July 3, 2023

Re: **Marysville 44th PRD – PA22-024 – Concurrency Recommendation**

Jesse Hannahs, PE
Traffic Engineering Manager

DRAWING: **C3**
 SHEET: **3** OF **9**

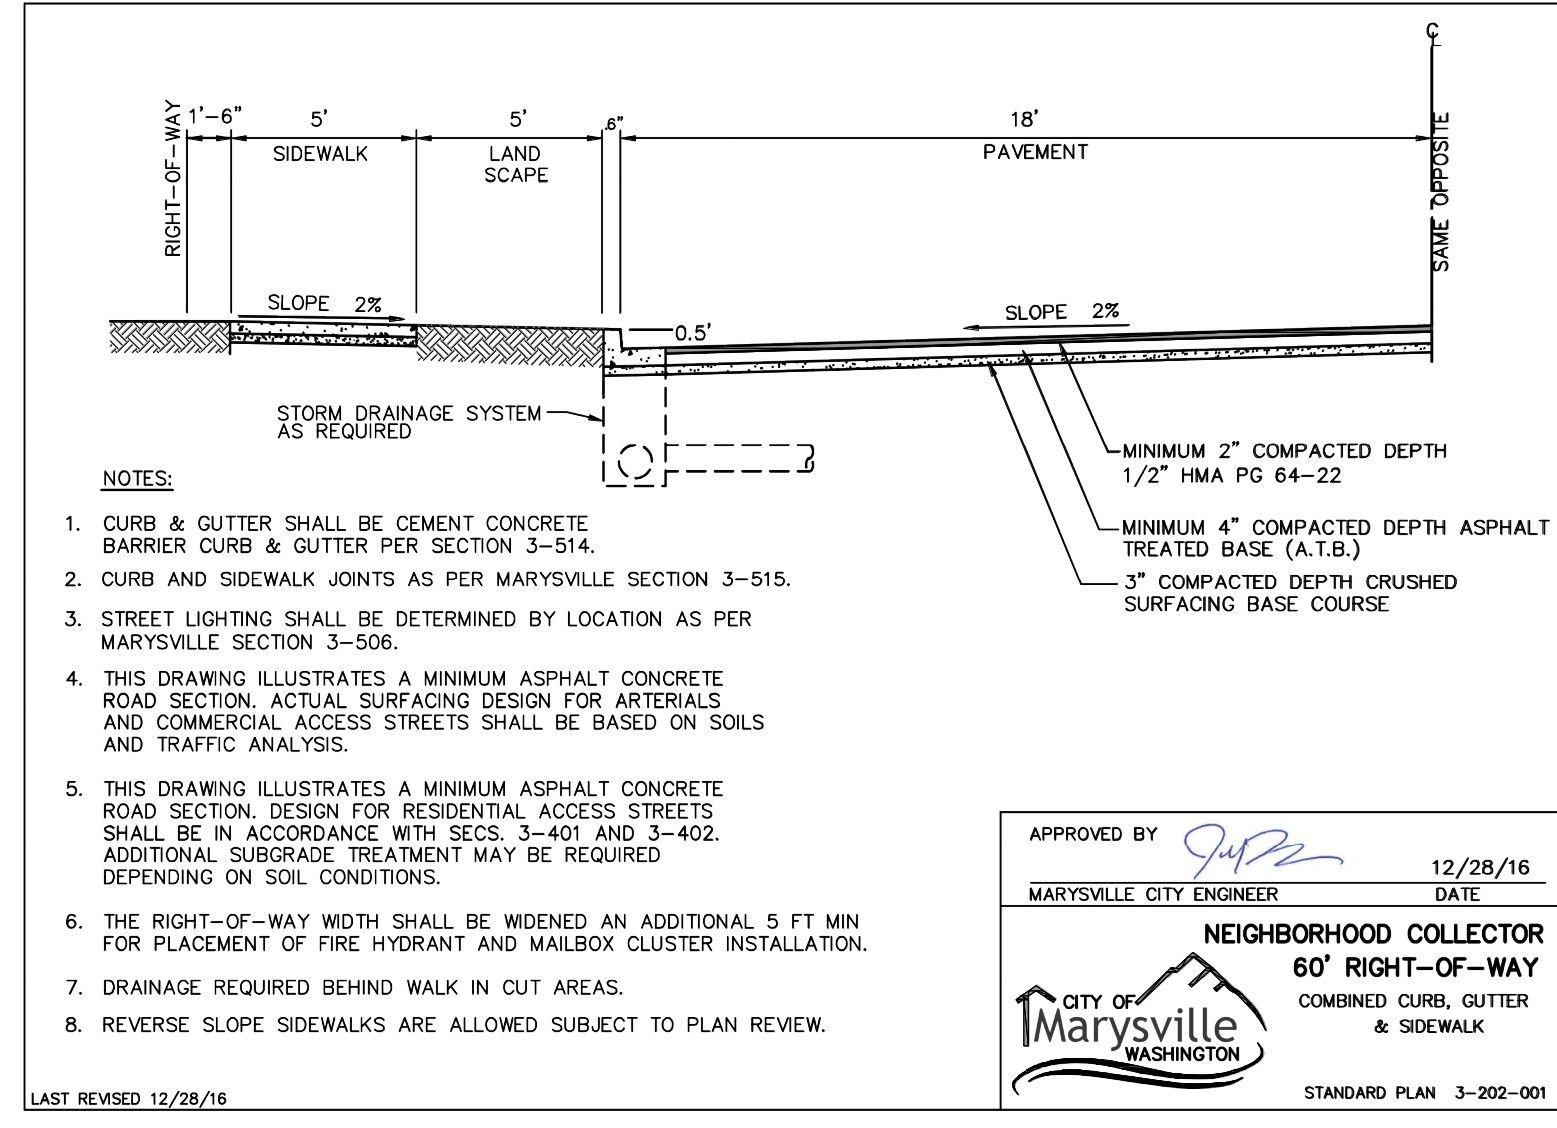
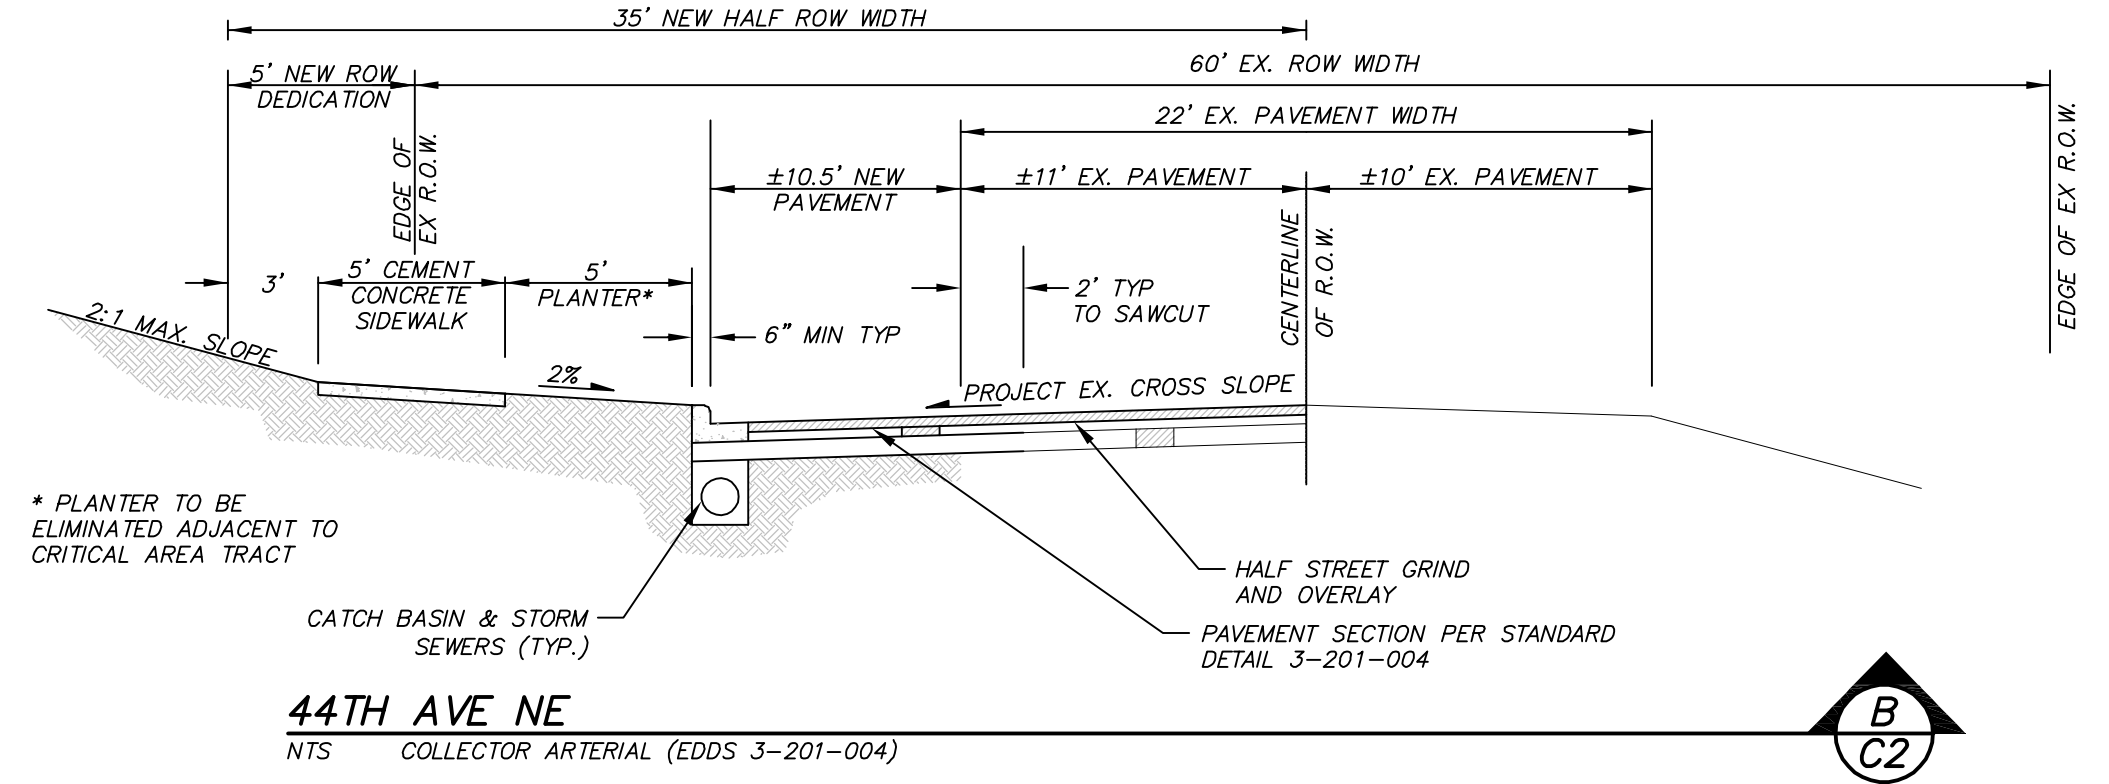
1. The applicant shall be required to construct frontage improvements along 44th Street NE and 75th Avenue NE, prior to final plat approval. Roadway improvements, channelization, site access and lighting plans shall be required to be reviewed and approved by the City Engineer, prior to construction plan approval.
 - 1.1. The westbound right-turn deceleration lane on 44th Street NE shall be consistent with WSDOT’s Design Manual (DM) Exhibit 1310-21 to mitigate sight-distance. The multiplier for downgrade shall also be evaluated.
 - 1.2. The westbound acceleration lane on 44th Street NE west of 75th Avenue NE shall be consistent with WSDOT’s DM Exhibit 1310-22. The northern 44th Street NE curb line shall be shifted south as feasible to create a planter strip up to the width shown in EDDS Plan 3-201-007

The design speed for the southbound right-turn curve may be used to interpolate this lane length. The multiplier for downgrade shall also be evaluated. The taper rate in EDDS 3-406 should be used instead of 300 ft.
2. The applicant shall be required to dedicate public right-of-way in order to accommodate the required frontage improvements along 75th Avenue NE and 44th Street NE and the new internal roadway (Road A),
